From: Sarah Burrow <Sarah.Burrow@arun.gov.uk>
Sent: 28 July 2021 16:55
To: Planning.Responses <Planning.Responses@arun.gov.uk>
Cc: Maria Tomalova <Maria.Tomalova@arun.gov.uk>
Subject: RE: Planning Consultation on: AL/90/21/DOC

Engineers Comments Regarding Surface Water Drainage

Application No: AL/90/21/DOC

Site Address: Land West of Fontwell Avenue 1 Fontwell Avenue Eastergate PO20 3RU

PROPOSED SITE PLAN PURSUANT TO CONDITION 3
SCALE 1:200

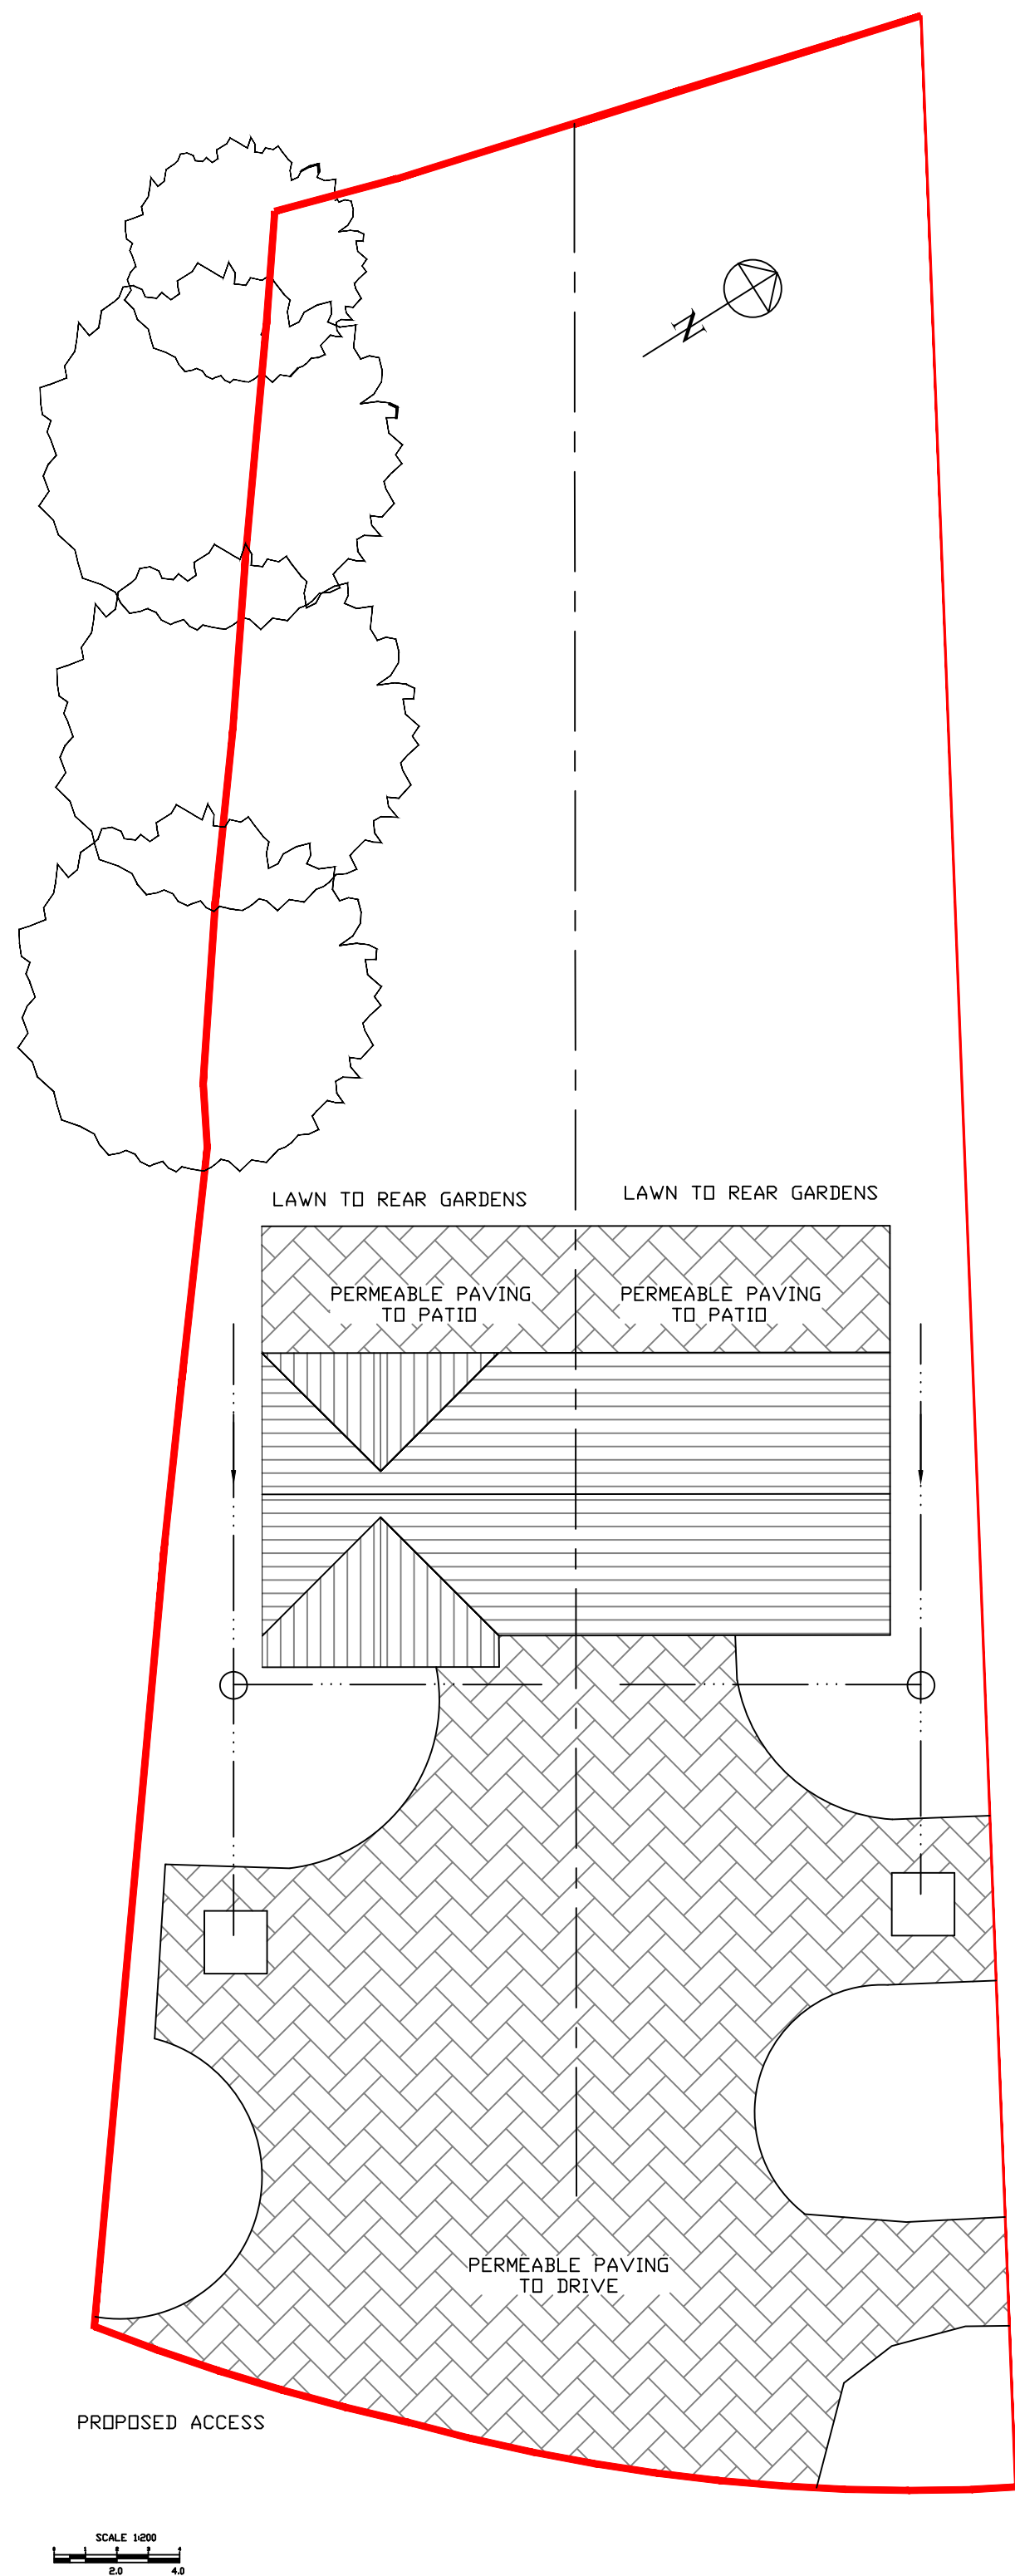
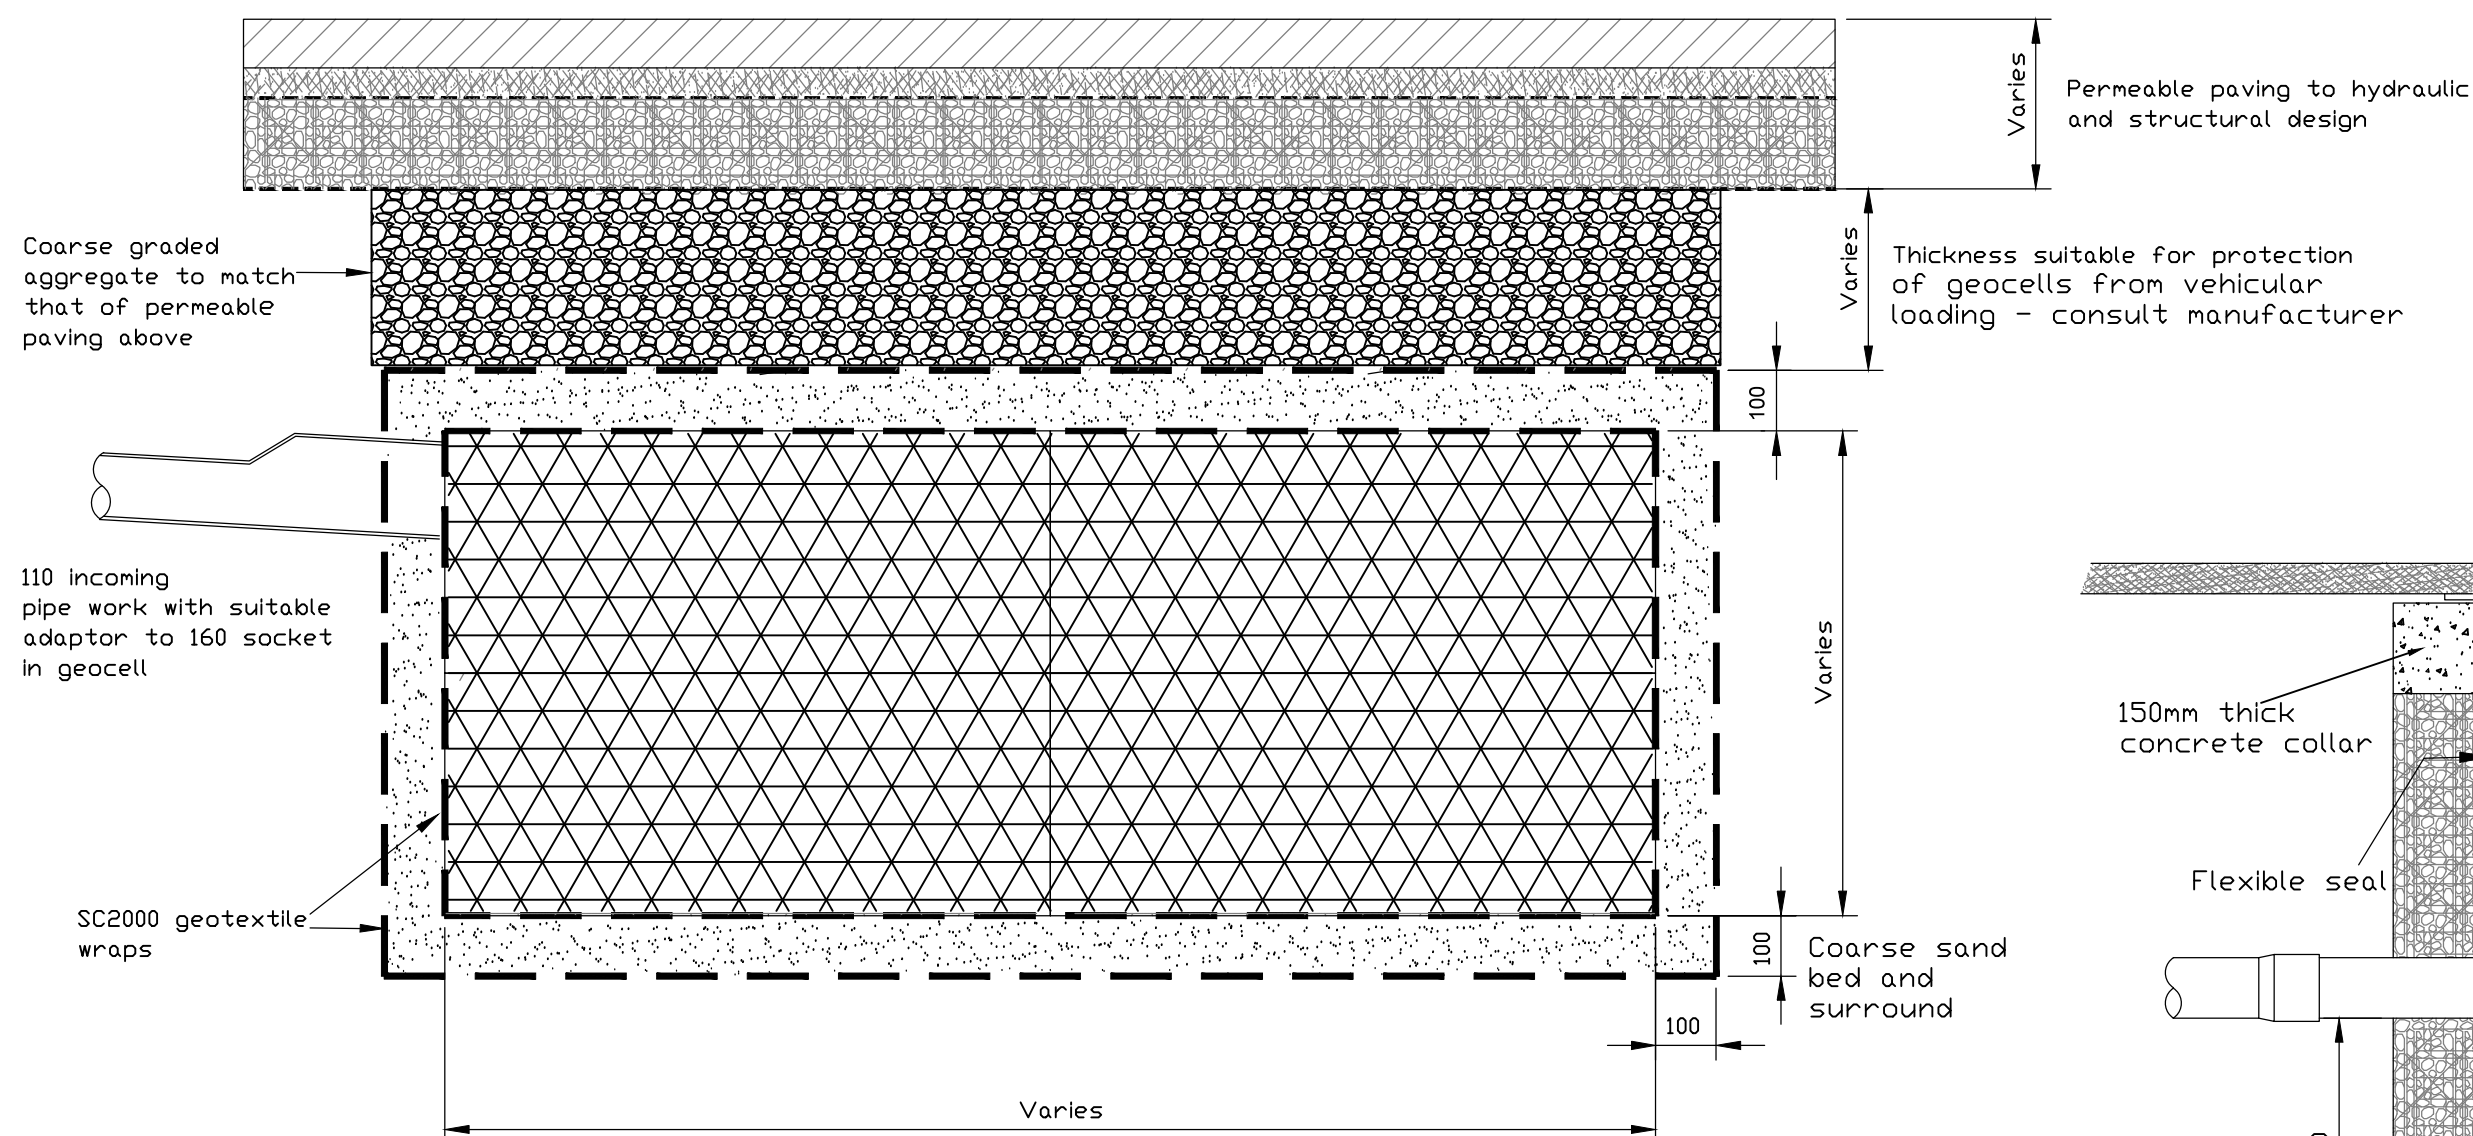
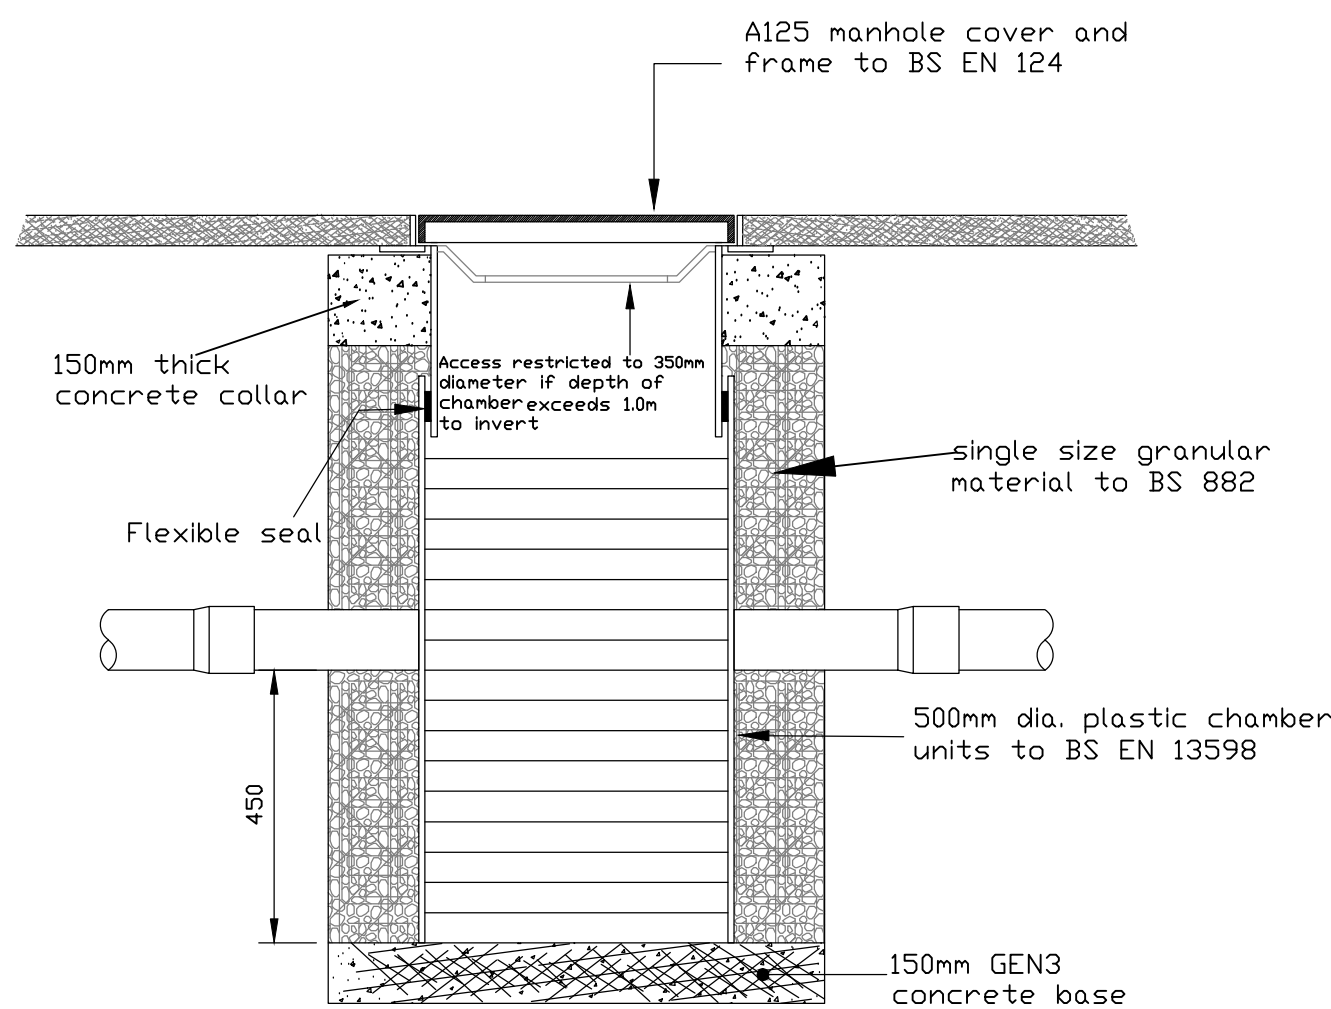
1. Groundwater monitoring; Insufficient groundwater monitoring has been undertaken, it is stated, "A little groundwater was found at the base of a borehole in the lowest part of the site at 1.96m bgl during the investigations in March 2017." We would expect the applicant or their engineers to agree with us the level of groundwater monitoring required for the site. This was highlighted within the ADC Drainage Engineer's consultation on AL/136/17/PL. As a minimum, for a site of this size we would expect to see four observations over two wet months (normally December-February). If the applicant has any further groundwater monitoring observations, even historic ones, from this site or any neighbouring sites please can these be provided to support the design.

2. Infiltration testing; please supply further detail regarding the infiltration testing that was undertaken on the site. My initial impression is that the infiltration testing was undertaken in spring (April) rather than winter. This does not represent worst case conditions. Please confirm the following details:

- a. Exact dates of testing.
 - b. Dimensions of test pits (including depth).
 - c. Locations of test pits.
 - d. Results and calculations of infiltration rates.

4. The drainage layout lacks sufficient detail. Please consult our Drainage Checklist for a comprehensive list of the requirements for a surface water drainage Discharge of Conditions submission – paying attention to Note 10.

5. Construction detail drawings: Construction detail drawings need to be provided for pipe bed and surround.
